Arun District Council
Arun Civic Centre
Maltravers Road
Littlehampton
West Sussex BN17 5LF
Planning & Building Control General Enquiries
Tel: (01903) 737756 Fax: (01903) 730442
Dx: 57406 Littlehampton
Minicom: 01903 732765
e-mail: planning@arun.gov.uk
website: www.arun.gov.uk/planning

Application No: AB/28/21/PL
Site Address: 19A, 19B, 19C, 21, 23, 25, 27 and 29 River Road Arundel BN18 9EY
Description of works: Works to reinstate boundary walls, balconies & outbuilding. This site may affect the setting of a listed building, affects the character & appearance of the Arundel Conservation Area & is in CIL Zone 2 (Zero Rated) as other development.

OWPC34472

5 Typical Balcony Elevations

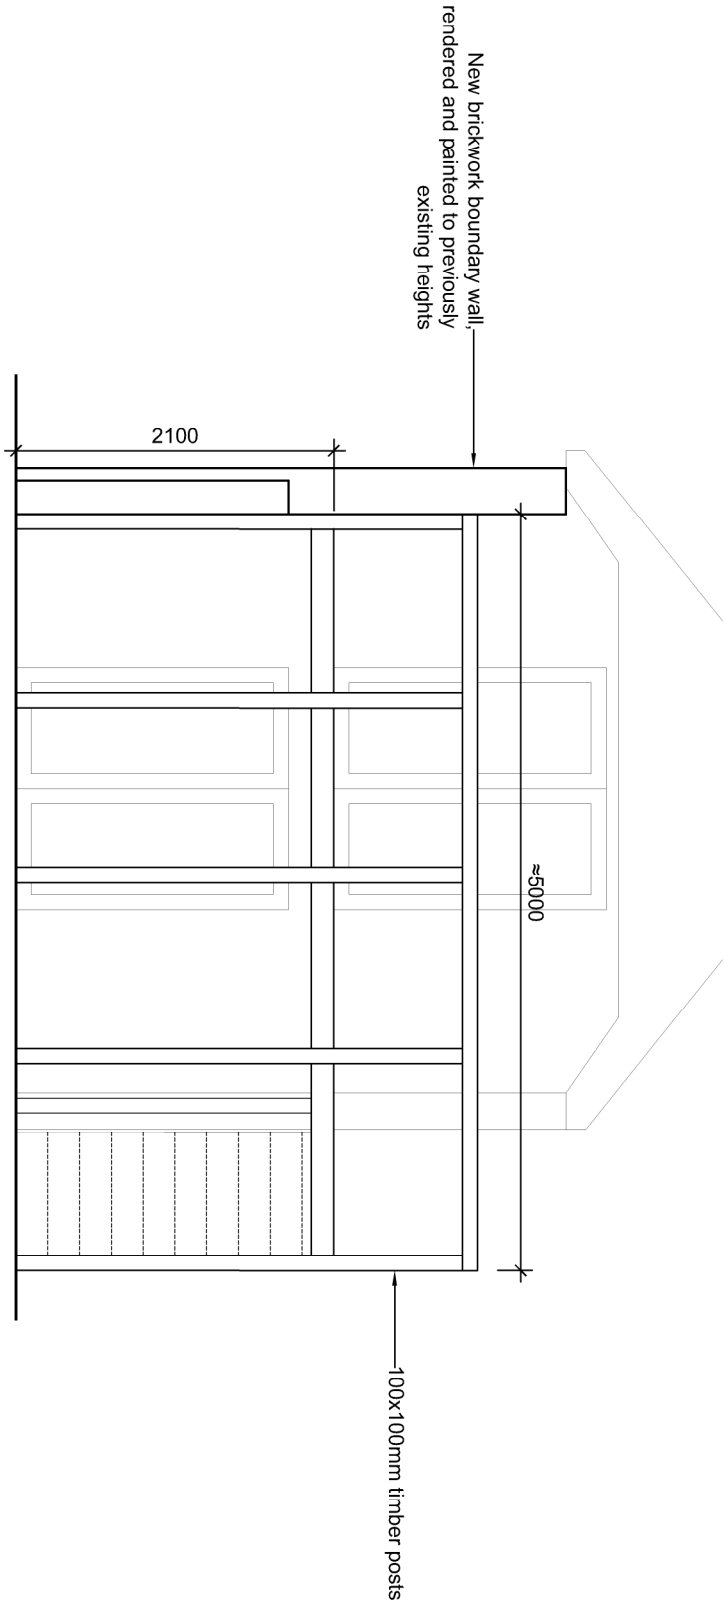
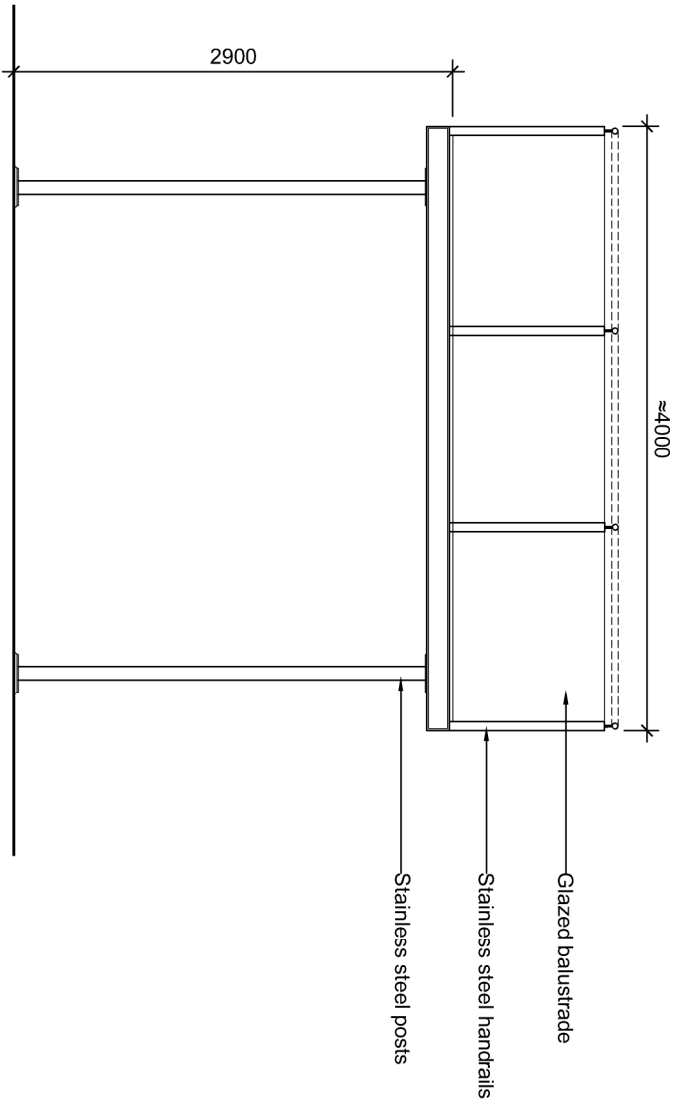
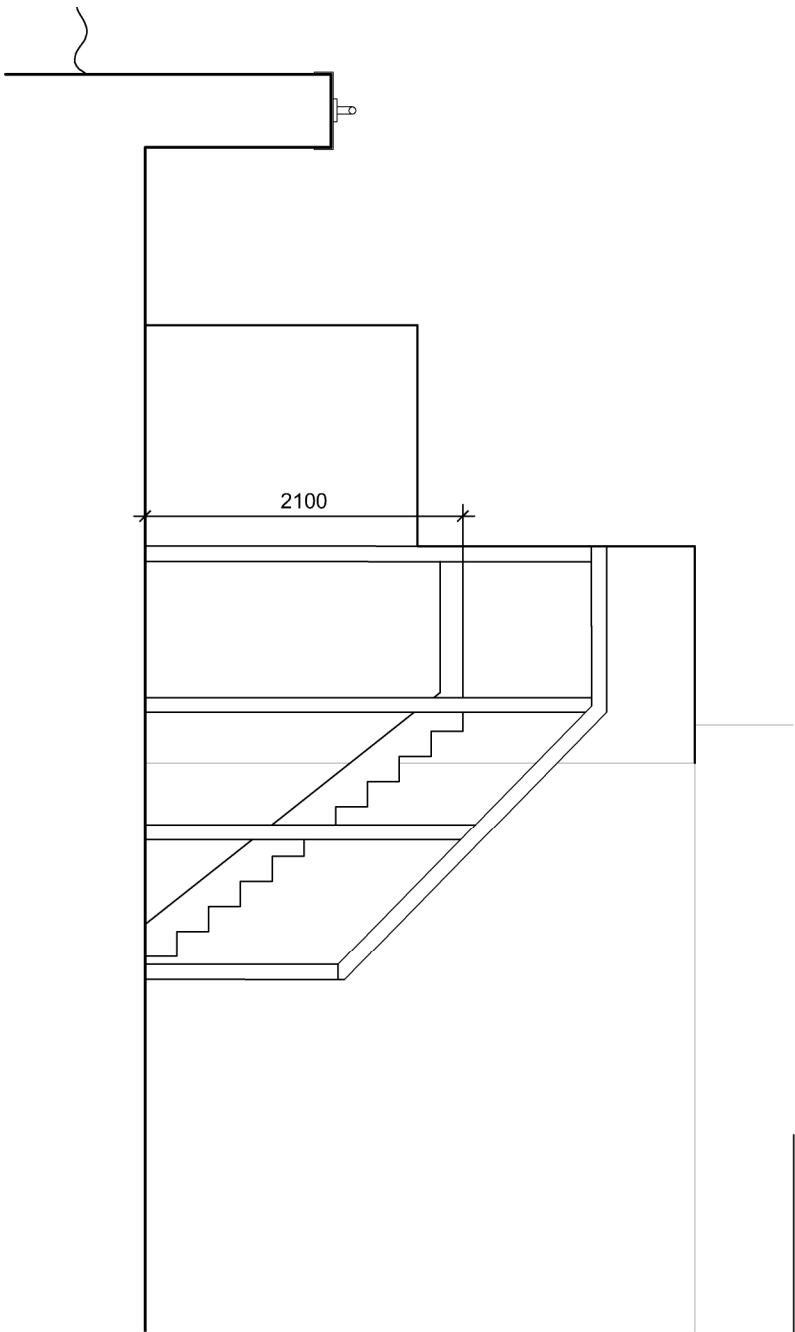
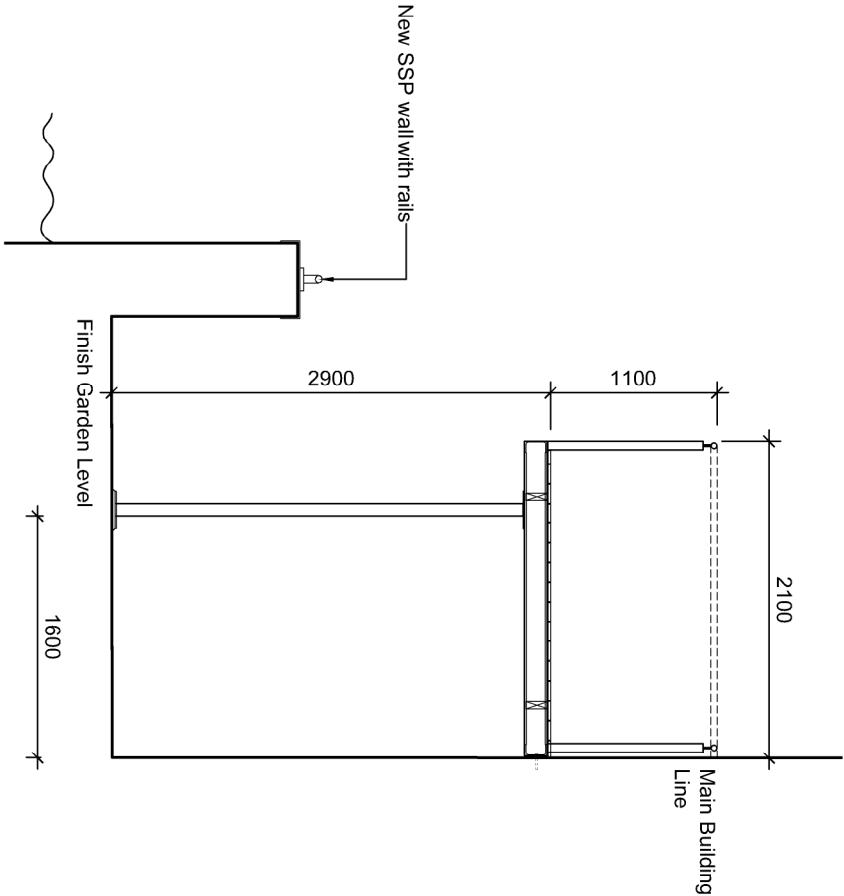
These works of reinstatement follow on from the recent essential repair works to the river defence walling. It is perhaps unfortunate that the proposed replacement balconies to 19A and 19B River Road will seemingly not match that of 19C, given the attractive symmetrical design of the terrace. It is recommended that a sample of the brick or bricks to be used in replacement works should be submitted to and agreed by the Council. Subject to the use of appropriate detailing and materials it is considered that there will be no harm to the character or appearance of the conservation area.
